KIRKLEES METROPOLITAN COUNCIL INVESTMENT & REGENERATION SERVICE

DELEGATED DECISION TO DETERMINE APPLICATIONS FOR LISTED BUILDING CONSENT

Reference No:	2023/65/93163/W
Site Address:	57-59, Cliff Road, Holmfirth, HD9 1UY
Description:	Listed Building Consent for erection of extensions and alterations to one dwelling to form 2 dwellings, demolition of existing external store, widen parking bay, improve external steps and access, external and internal alterations
Recommending Officer:	Lucy Taylor

DECISION - REFUSED

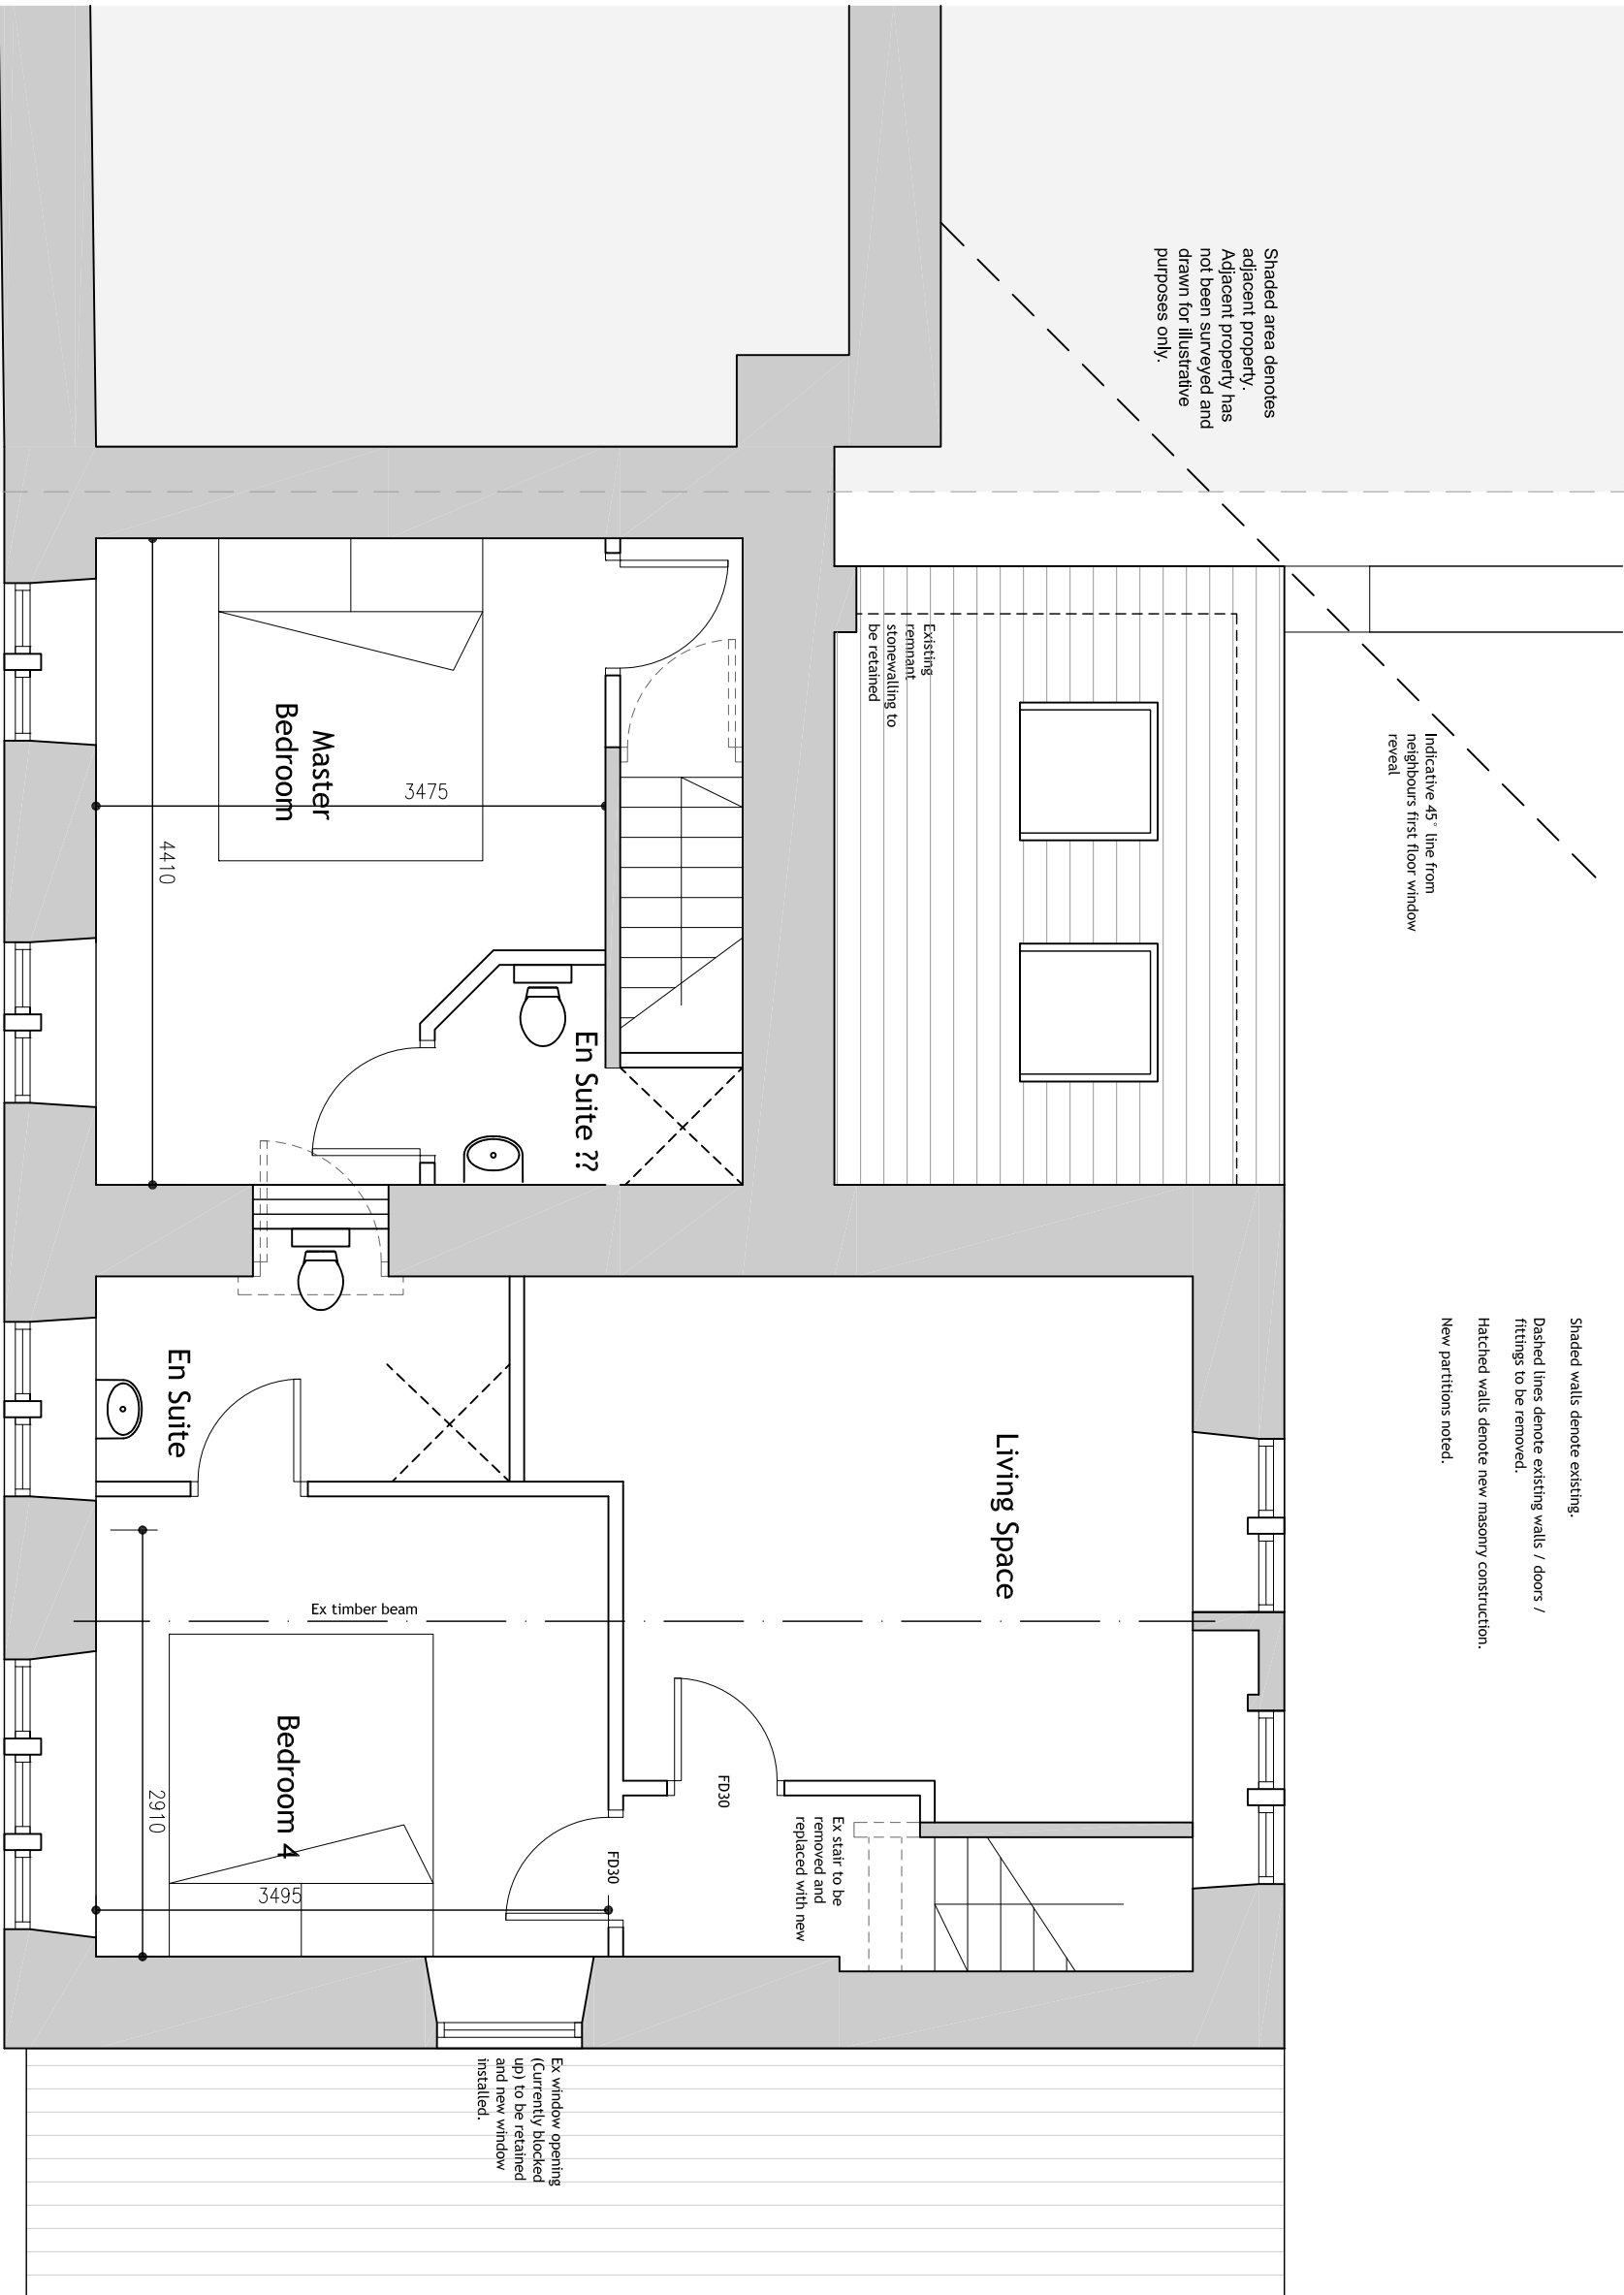
With regards to the erection of the proposed rear extension, it is considered that the loss of the existing external wall which forms a part of this

development, would result in harm to the building, as it is considered integral to its understanding. Furthermore, the two-storey rear extension itself is not considered to be subservient in size / scale and, while consent was previously granted at the site for an extension, this was only a modest single storey addition, which was set back from the elevation and incorporated the extant historic section of external wall.

In addition, KC Conservation and Design set out that they would be unable to support the level of loss of internal walls which form part of the historic plan form of the building. The planning agent responded to this via email communication setting out that they were believed to be 'modern stud partitions with no significant heritage value', however, no evidence was submitted.
